Transport  
for NSW

TfNSW Reference: SYD21/00314/03  
DPE Reference: SSD-15882721

**RESPONSE TO SUBMISSIONS – DORAN DRIVE PLAZA PRECINCT – 2 MANDALA  
PARADE, CASTLE HILL**

**DRAWING TITLE**  
 12.5M HRV TRUCK TURNING PATHS  
 Entering Dedicated Loading Dock Area  
**ADDRESS**  
 Doran Drive, Castle Hill

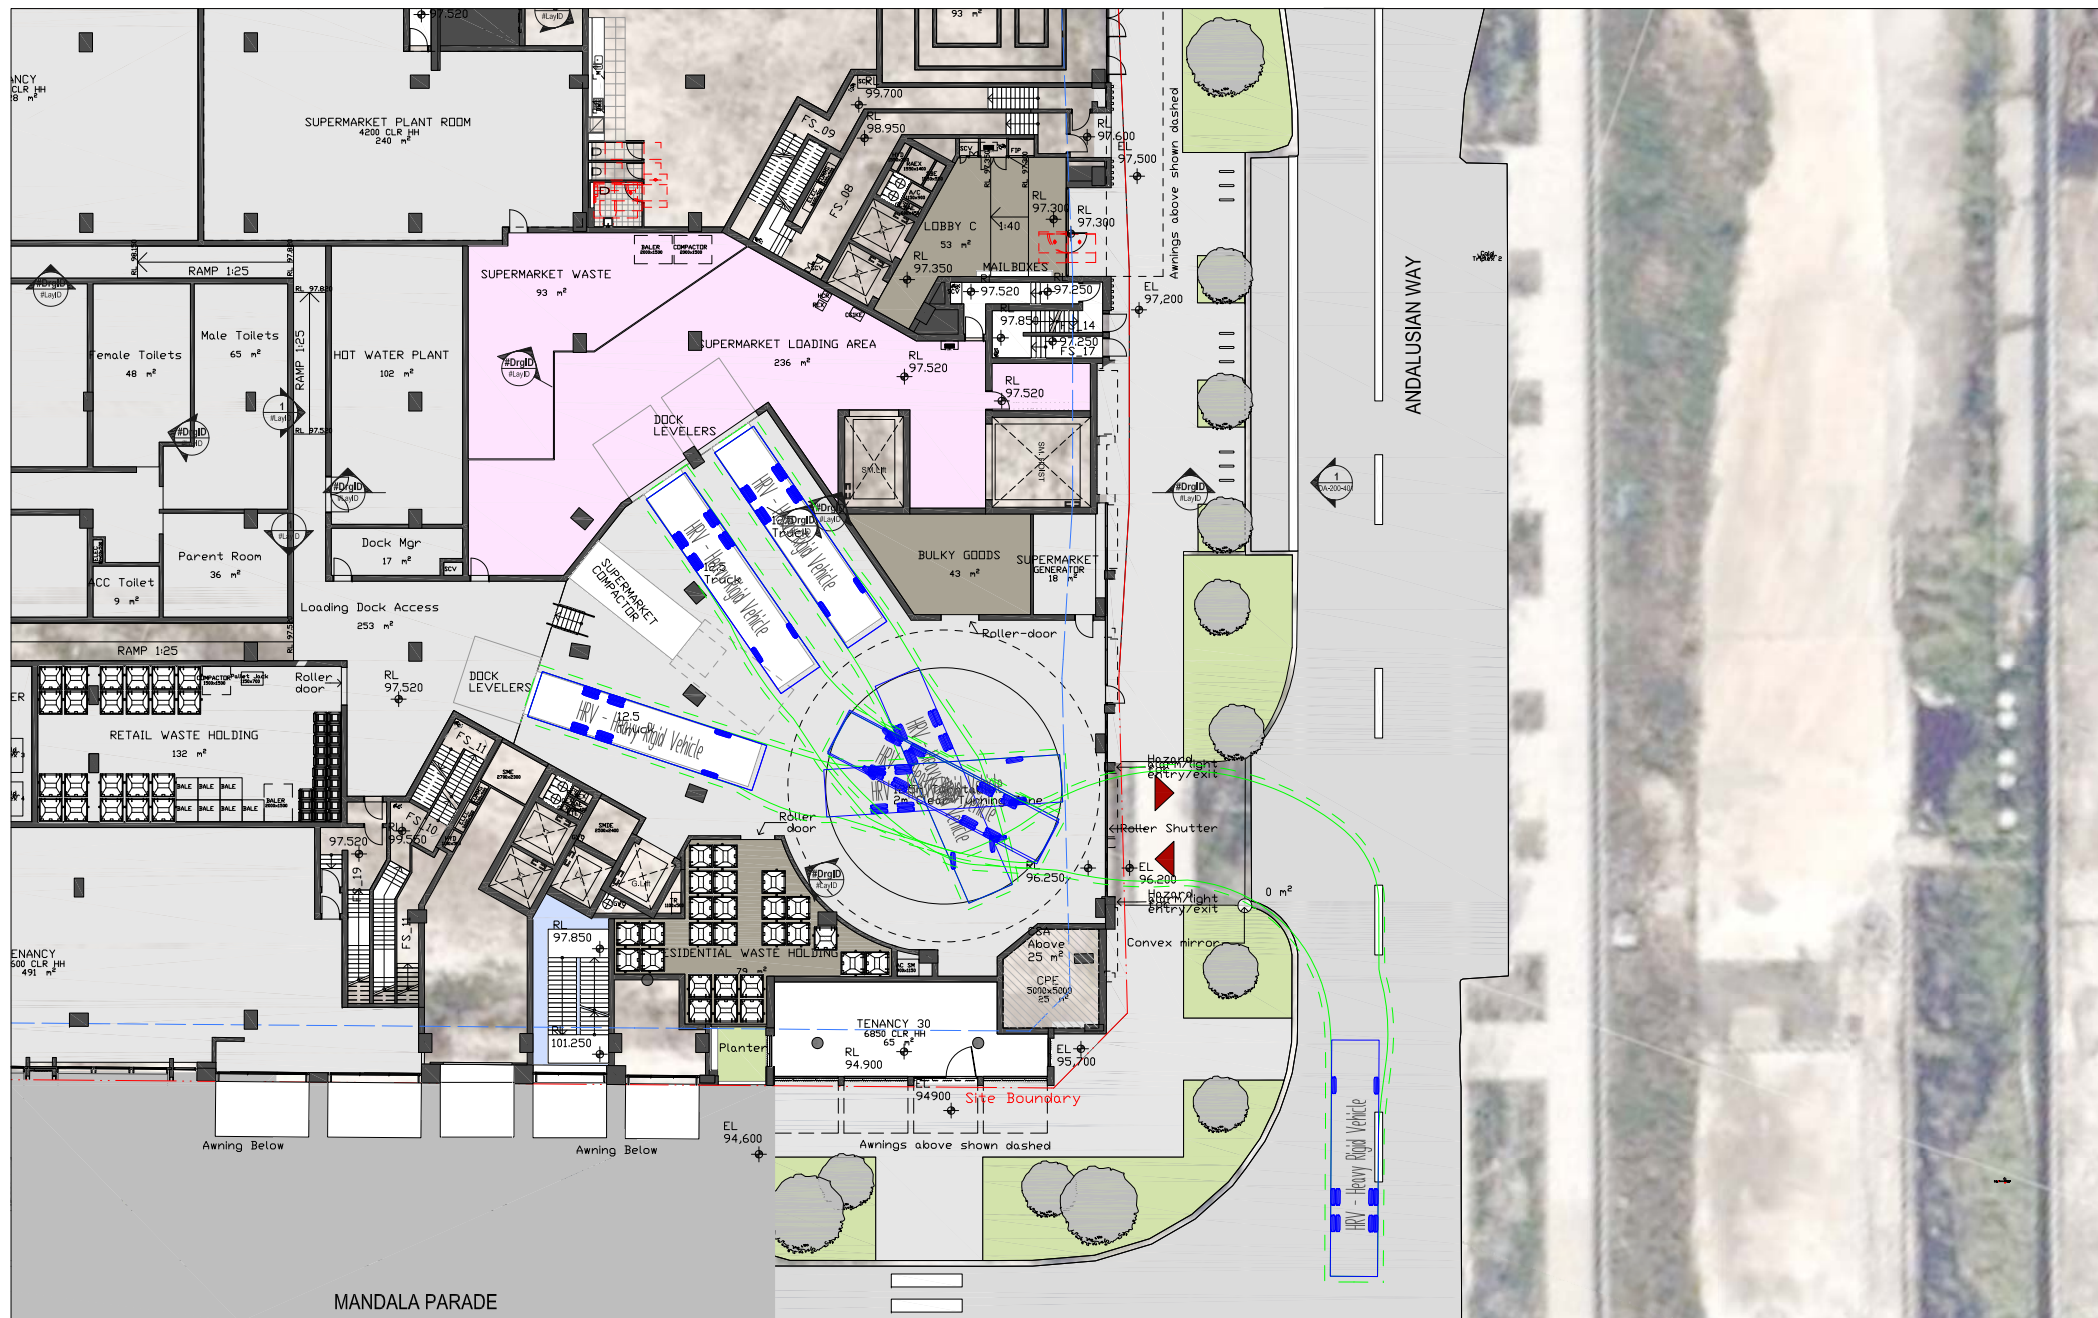
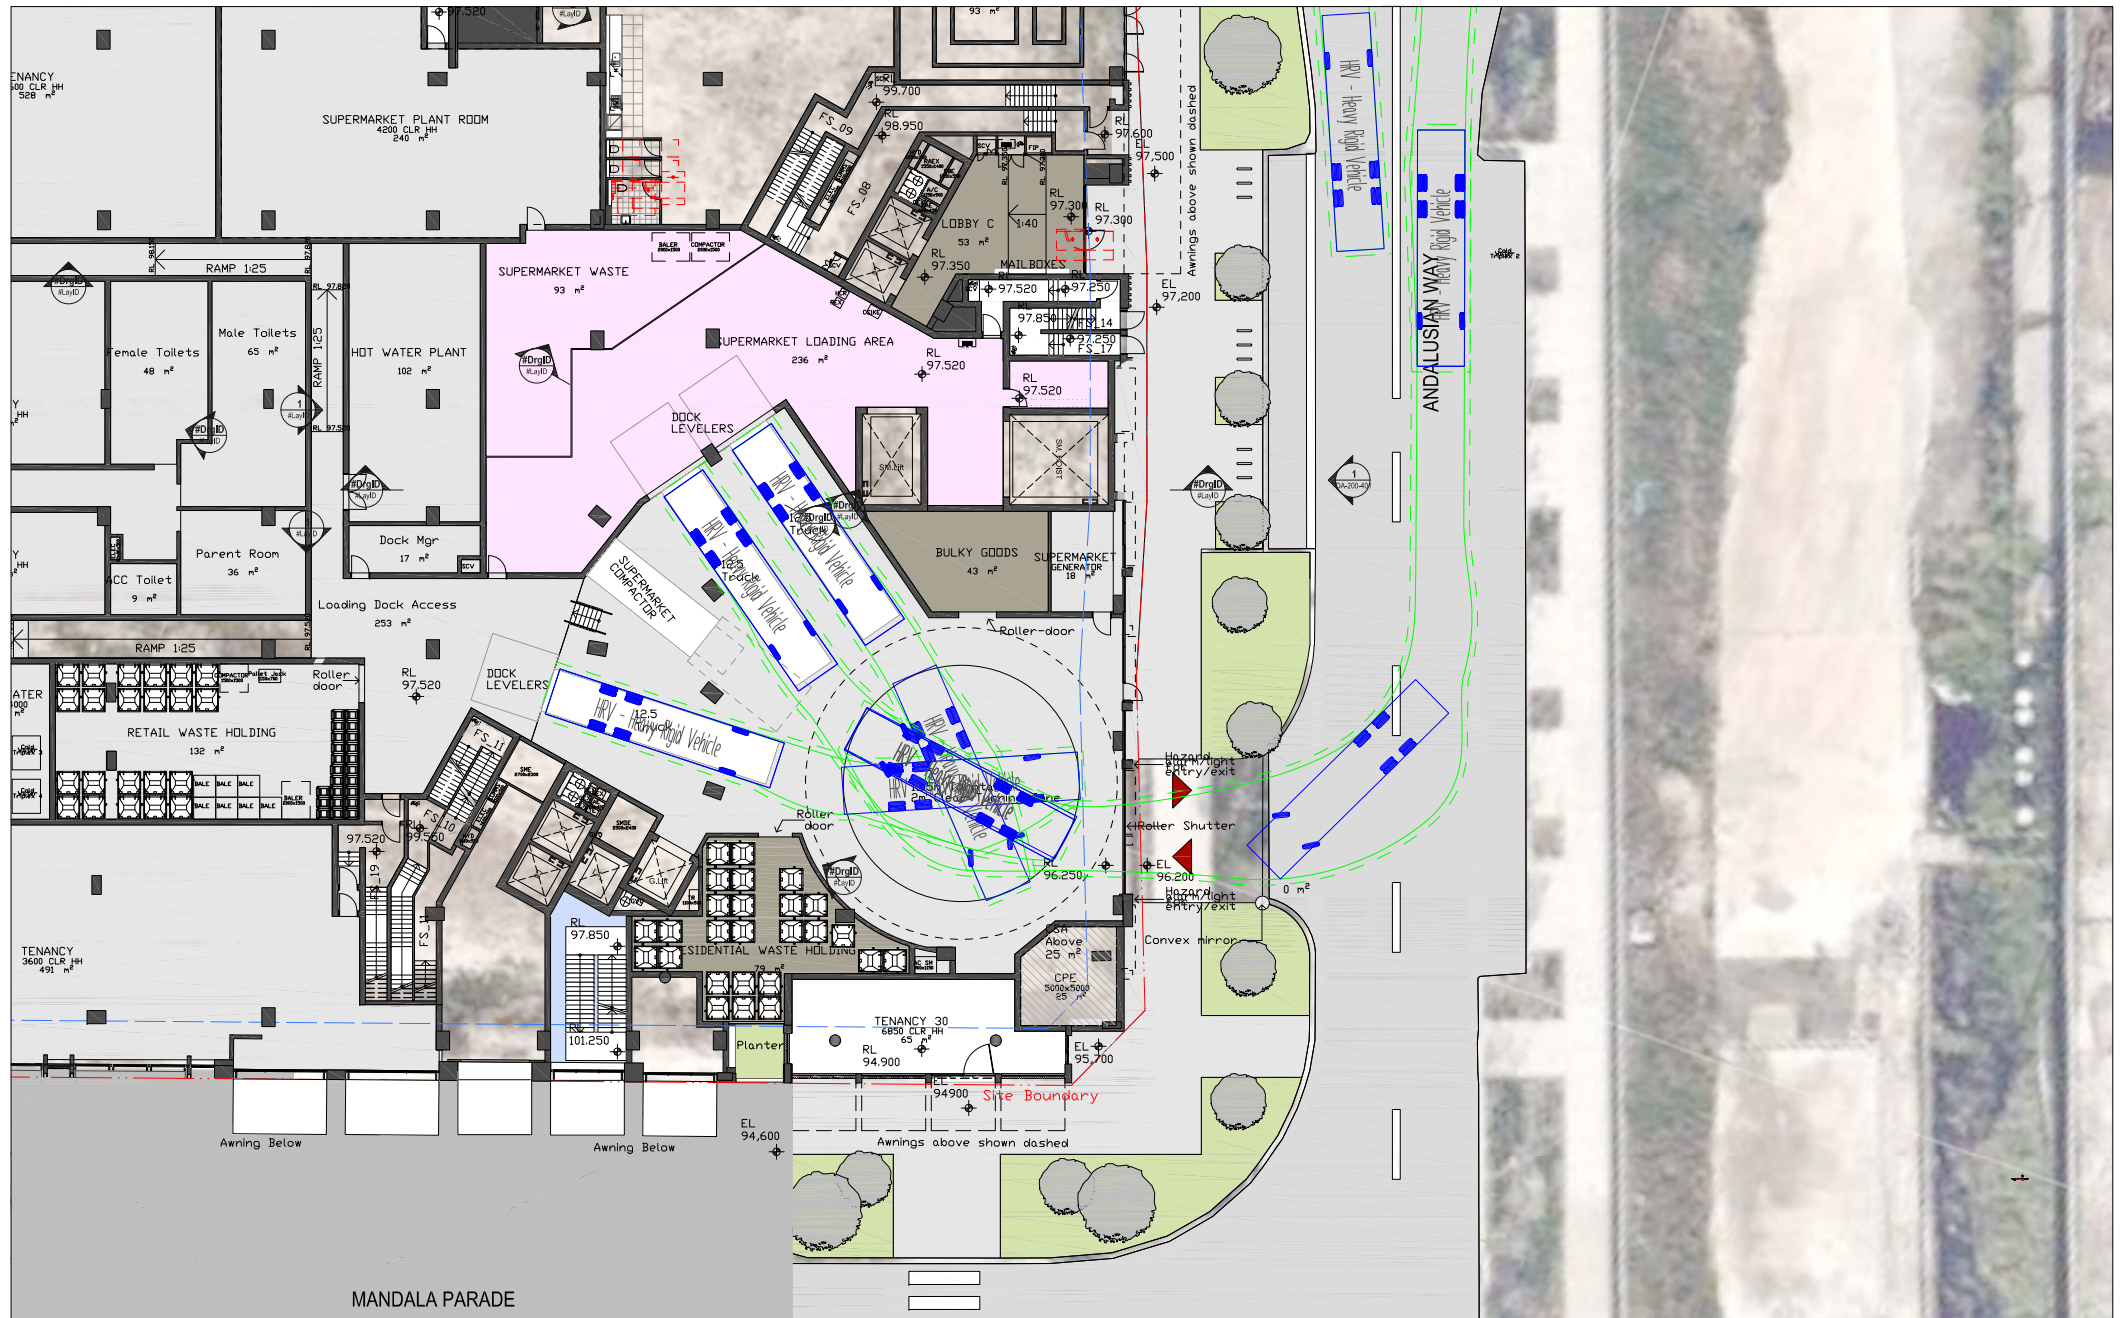
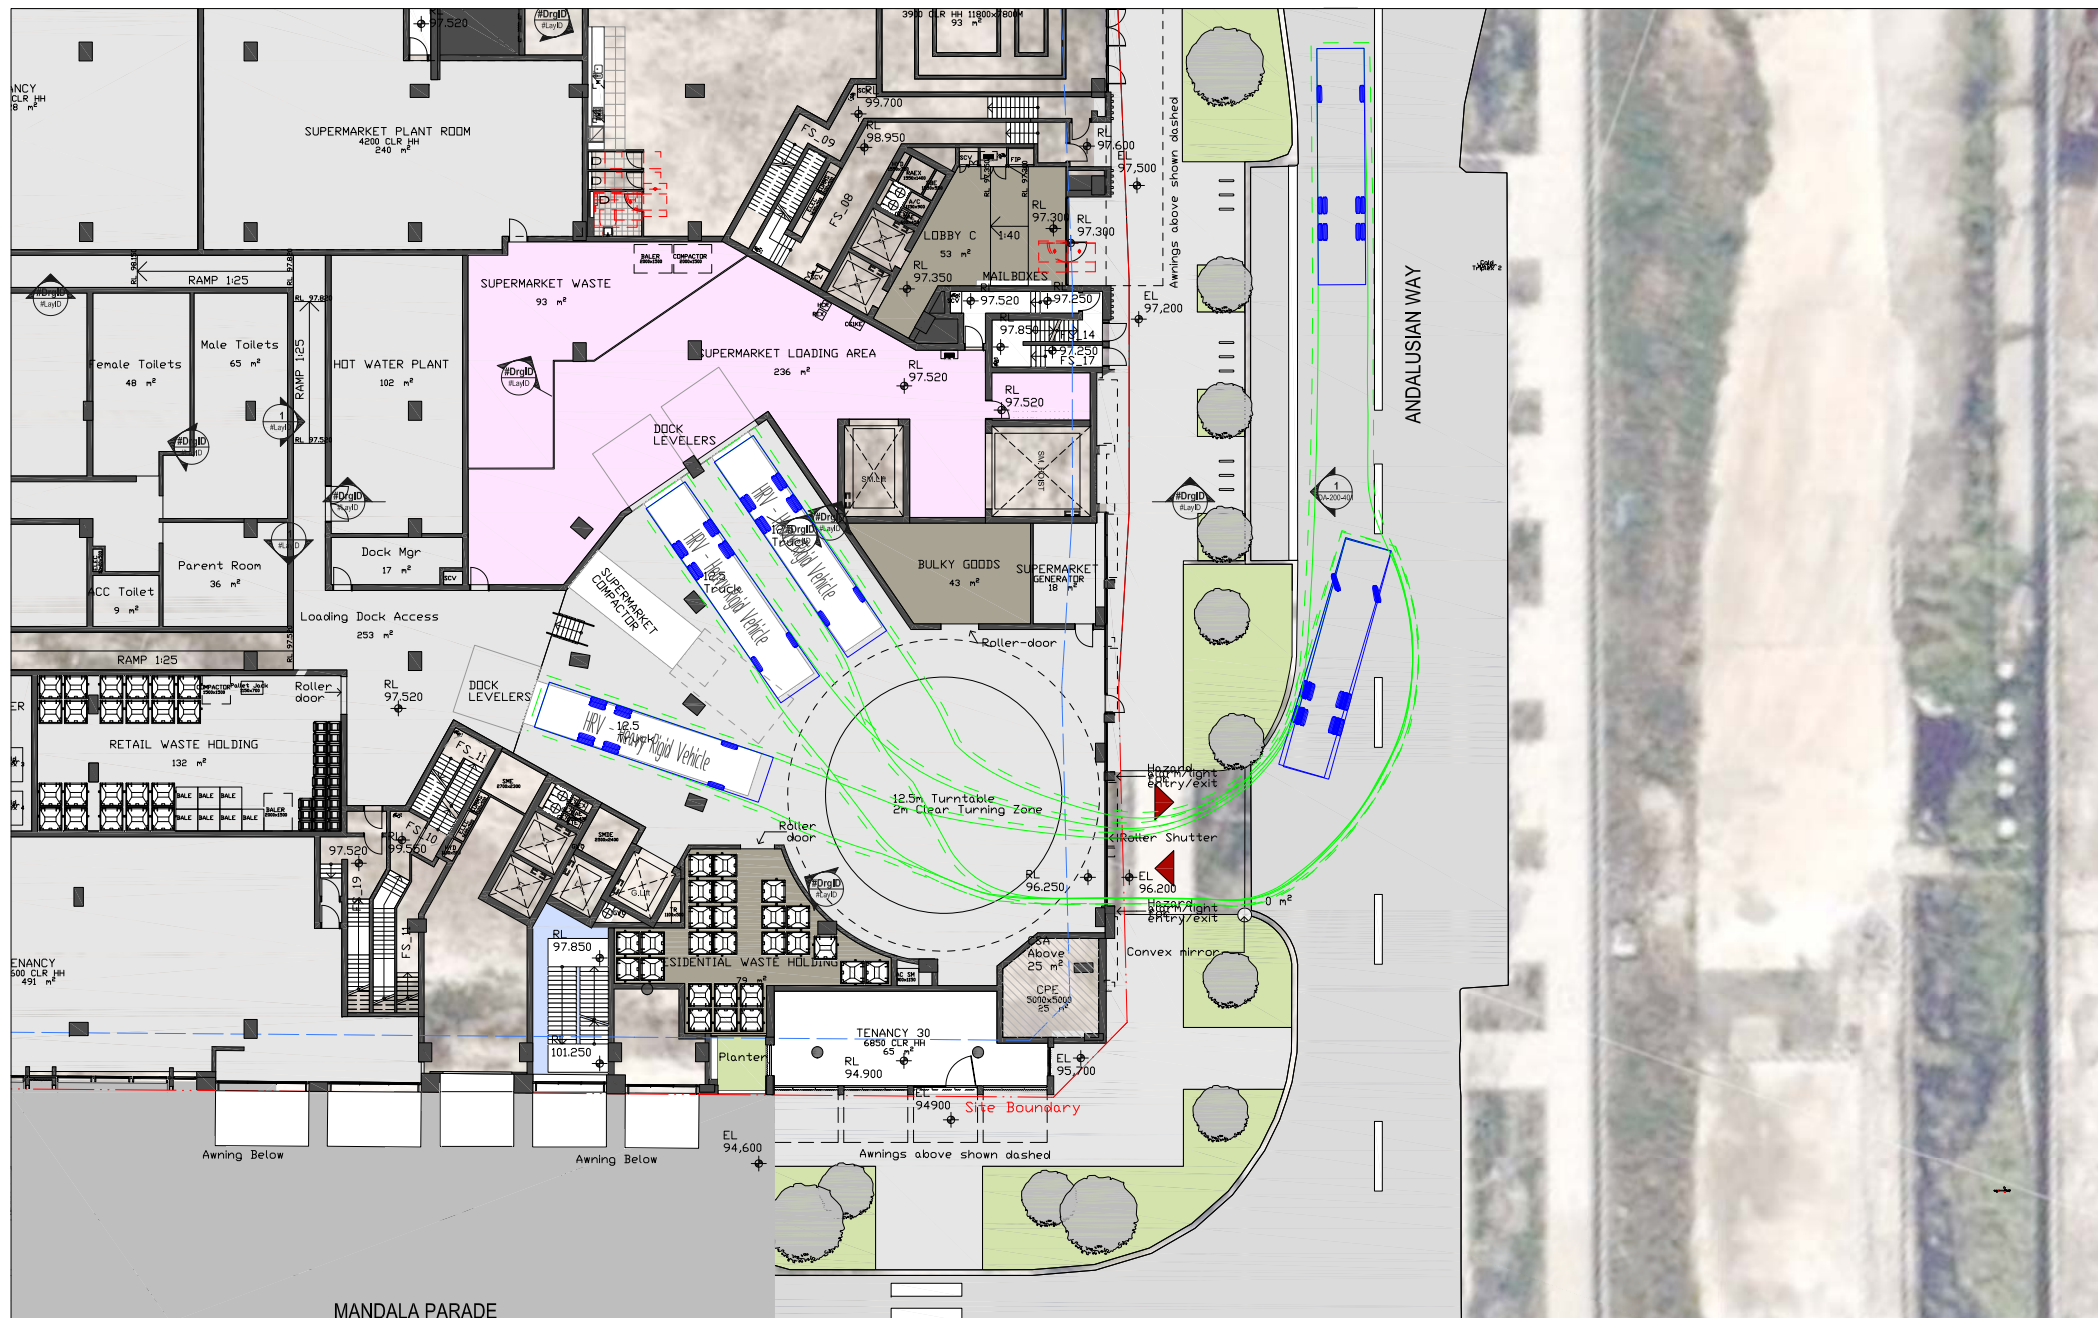
1. The development should be in accordance with the approved Hills Showground Station Precinct Concept SSDA.
2. Consideration must be given the proposed vehicular access to a loading dock at the southern end of the Andalusian Way will not impact upon the pedestrian crossing proposed with the Precinct East development proposal.
3. The proponent is to consider minimising any impacts that proposed landscaping will have on visibility to traffic signals and existing/proposed pedestrian crossings.
4. A Green Travel Plan (GTP) is required to be prepared prior to occupancy.
